File No: NTH24/00543/001

RE: Review of Environmental Impact Statement (SSD-70748466) - Advice on EIS - Huntlee New Town - Stage 2 - Wine Country Drive Rothbury

TfNSW has reviewed the referred information and provides the following comments to assist the consent authority:

DRAWING TITLE
CONCEPT CIVIL
ENGINEERING PACKAGE
INTERSECTION A-X - CIVIL WORKS
PLAN - SHEET 1

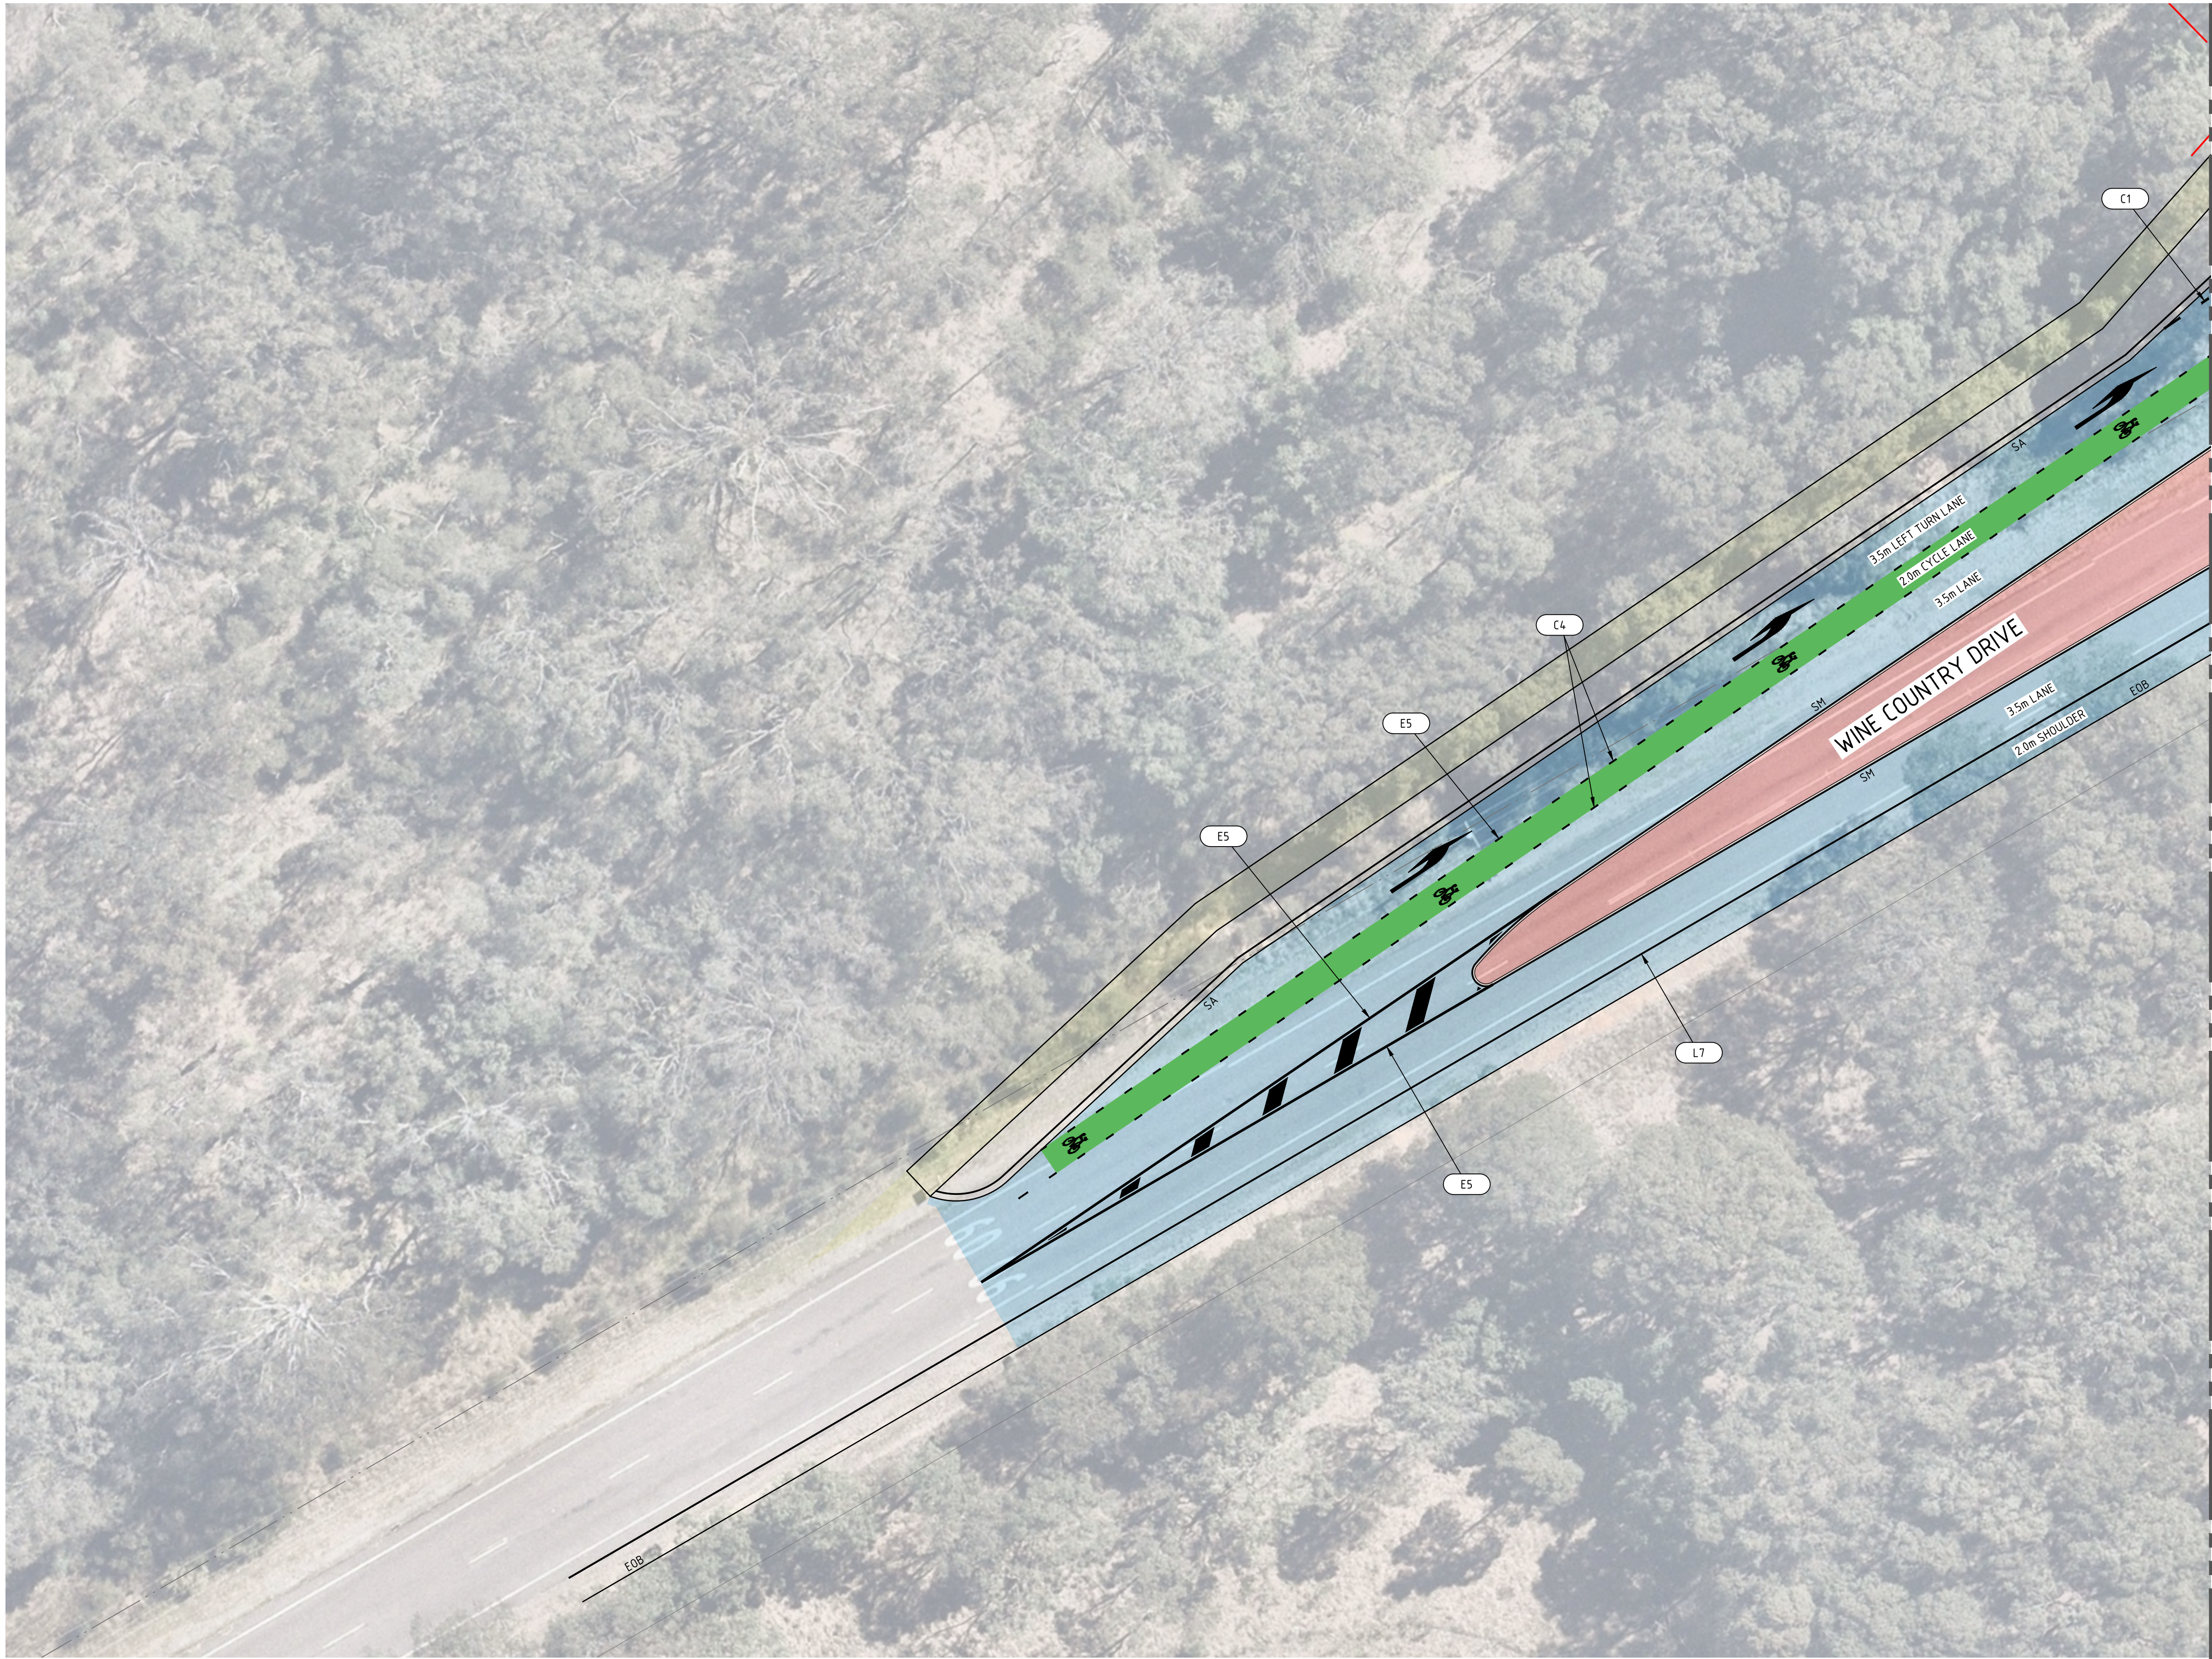
- Road Design (A-7 aka A-X)
 - Safe Intersection Sight Distance (SISD) should be considered at design speed i.e. posted plus 10km/hr and demonstrated, with 3d data provided to prove that adequate sight distance is available (also refer <https://elevation.fsdf.org.au/>)

- The new intersection into the Collector Street should have a median in WCD as there is not enough width to pass a right turner.
 - Then designer should consider a AUL or AUL(s) into the new street.

- Consideration of access to the bus stops on either side of WCD should be considered. A refuge may be required on the crest near the Collector Street assuming pedestrian sight distance is in accordance with Austroads recommendations. Pathways should be connected to the refuge and bus stops.

- The right turn out of Thomas and Mitchel Streets will become increasingly difficult, particularly due to the additional traffic to and from Huntlee and the crest at the Collector Street.

- Does the current heritage plaque need to remain in its current location? If so, is there need for barriers etc.?
 - How will this integrate with future intersection A-8?

DRAWING TITLE CONCEPT CIVIL ENGINEERING PACKAGE INTERSECTION A-8 - VEHICLE SWEEP PATHS PLAN - SHEET 2

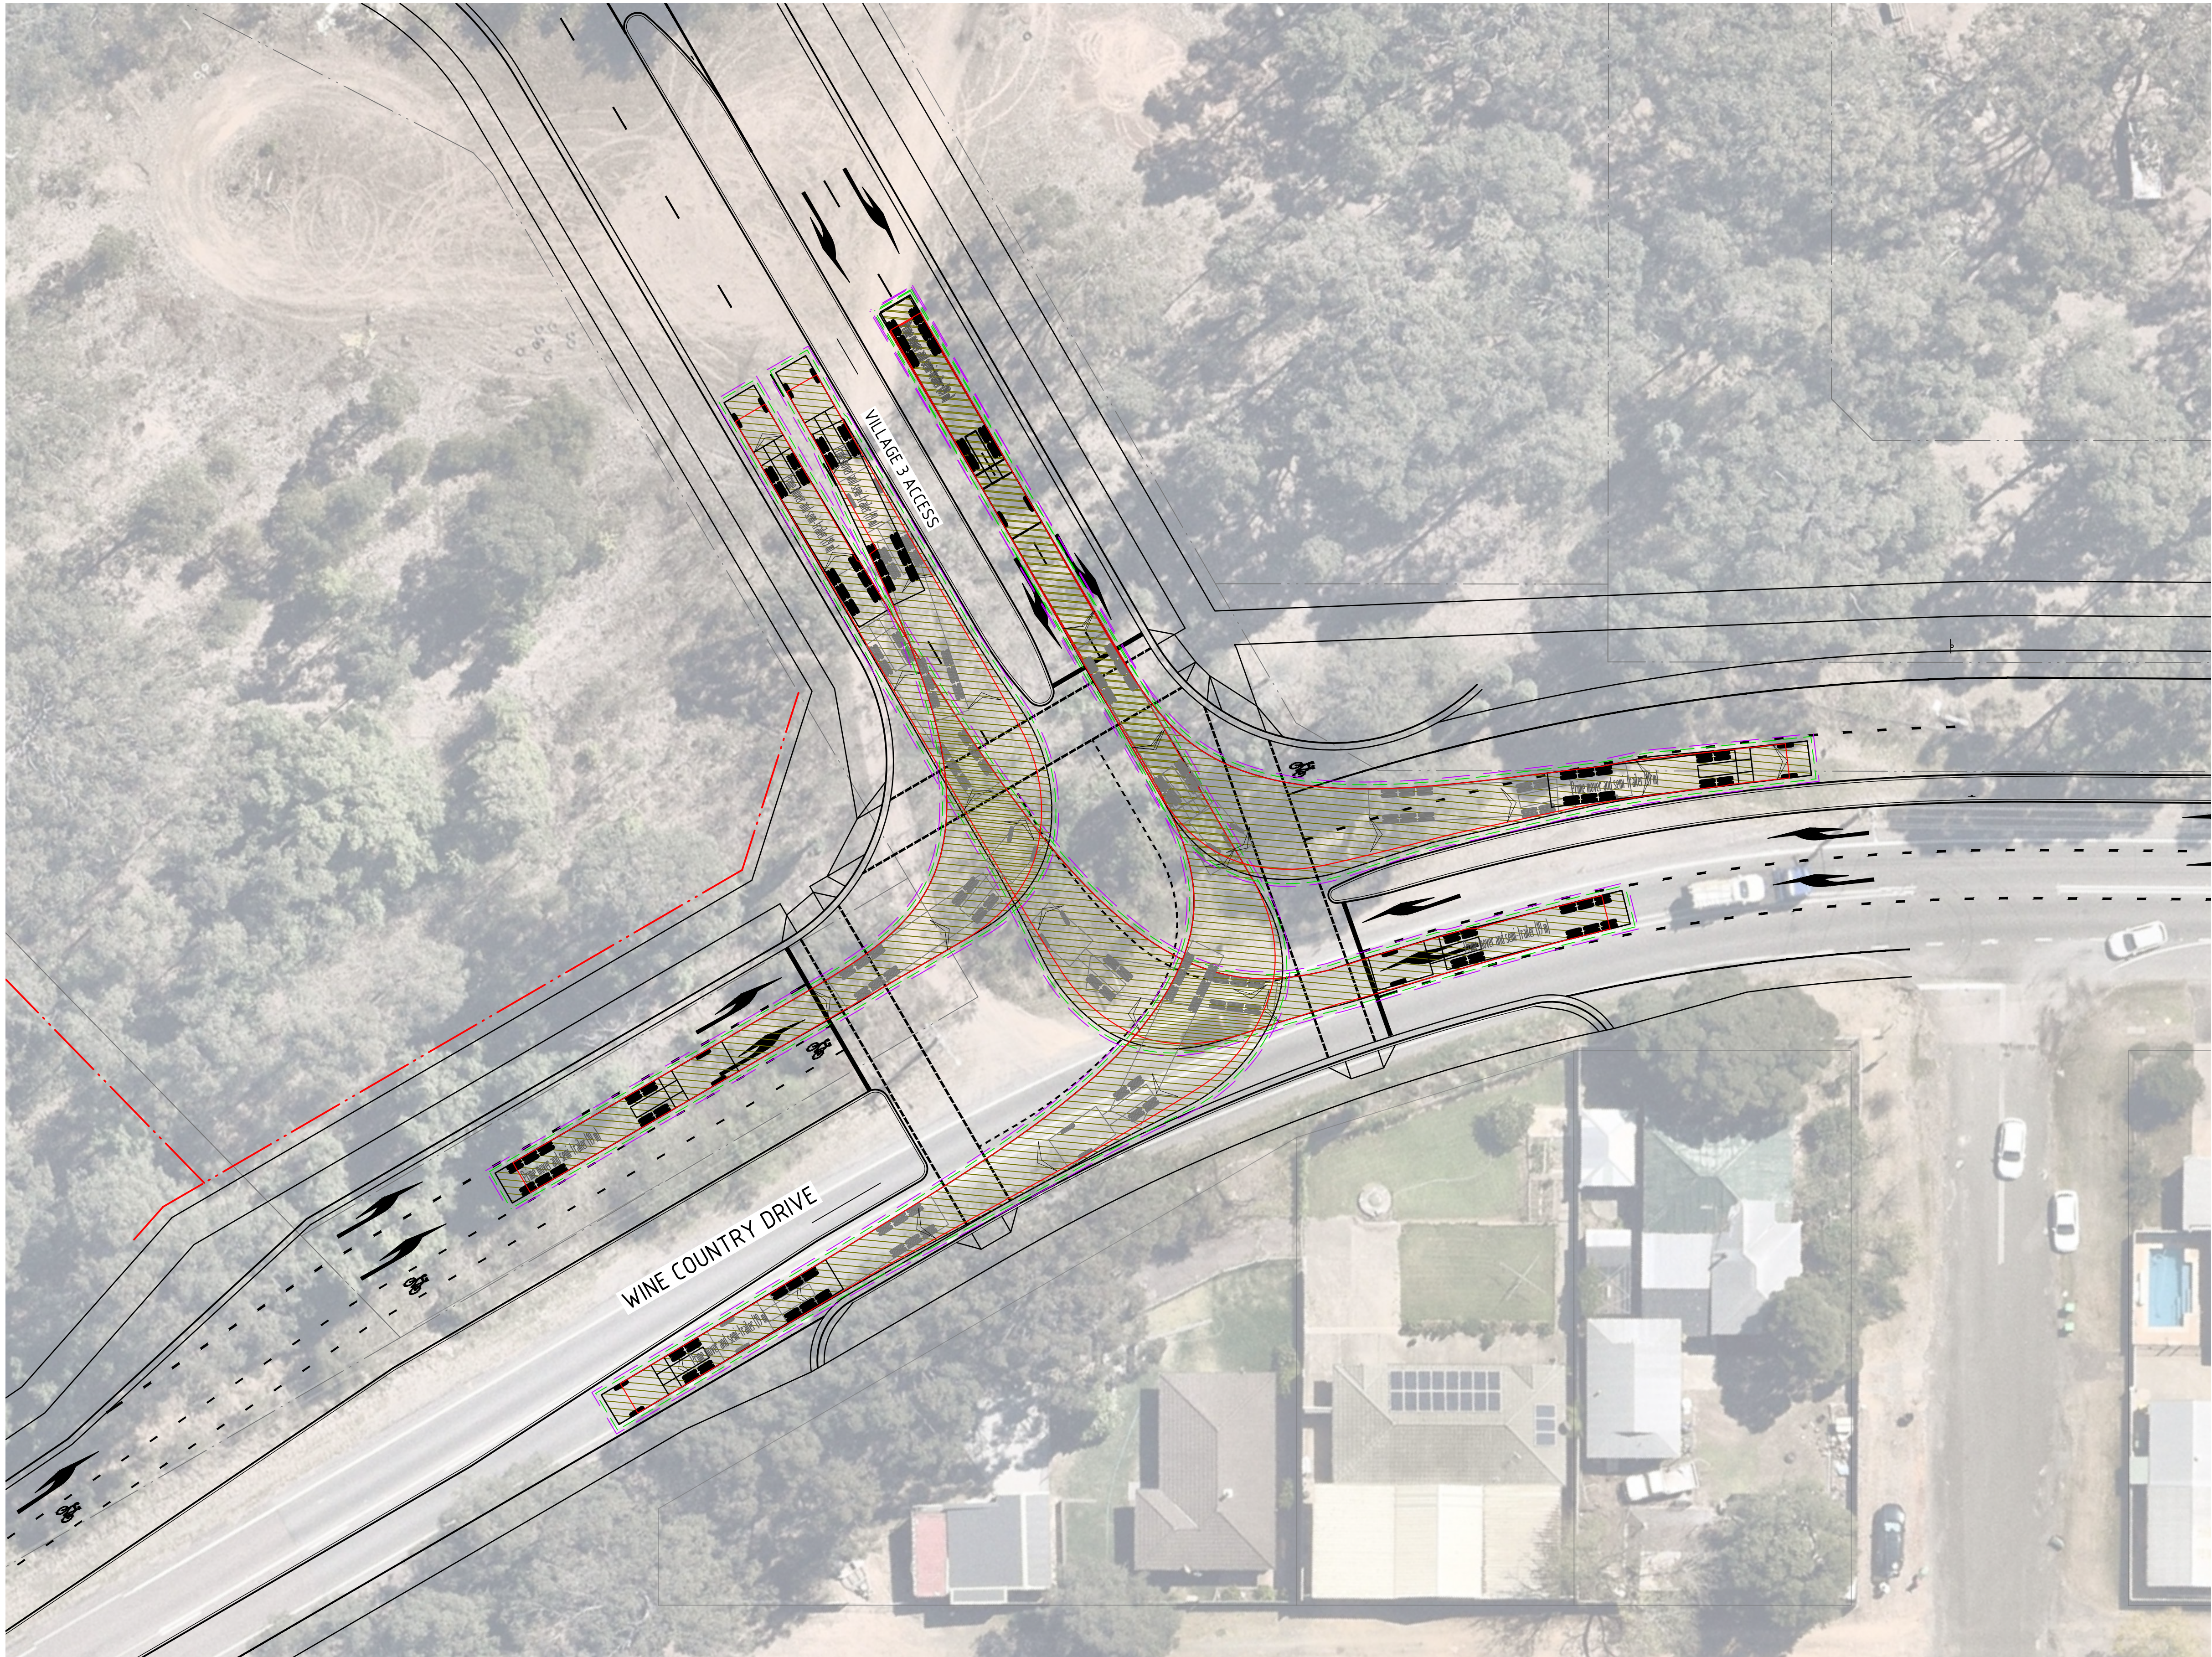
- Intersection A-8 – Further comment is sought on this intersection. Currently, the lots on the eastern side of WCD (Reid Street & Mayne Street) have opportunity to turn right in and right out. The proposed TCS will not permit them to make this movement. Also, the original Hyder report identified this intersection as a new roundabout in the full Huntlee development.
